20 September 2018

## **RESPONSE TO SUBMISSIONS | SSD 7662 MOD 1 | SITE 53, 2 FIGTREE DRIVE, SYDNEY OLYMPIC PARK**

Table 1 – Response to submissions

title:
**GENERAL ARRANGEMENT
PLAN - LEVEL B01**

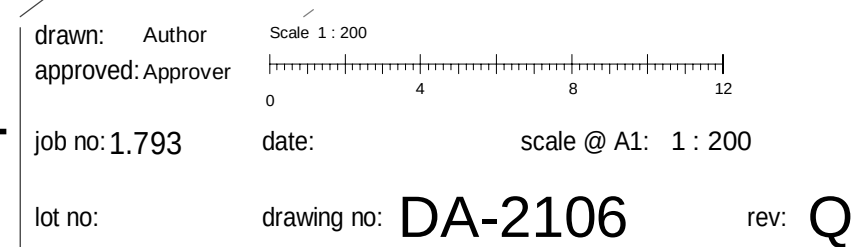
Area	Issue	Response	Ref doc
	Drawings and planning report include a workshop for bicycle storage on Level 1 that are not included in the BVN or Mirvac design verification statements.	The design verification statements have been updated to include a reference to this aspect of the proposed modifications.	Attachment A, Attachment B
	Planning report includes amendments to elevations to correspond with the approved floor plan for Level 17 through Level 23 that are not included in the BVN or Mirvac design verification statements.	The design verification statements have been updated to include a reference to this aspect of the proposed modifications.	Attachment A, Attachment B
	The BVN and Mirvac design verification statements include a courtyard added to an apartment on Level 1 in Building 5 that is not shown on the drawings or in the planning report.	<p>This adjustment is shown on the plans lodged with the modification application (refer to annotation 4h).</p> <p>A reference is also included in the planning report on page 8 and reads "awning added over substation at Level B01, subsequent expansion of unit balconies at Level 01."</p>	-
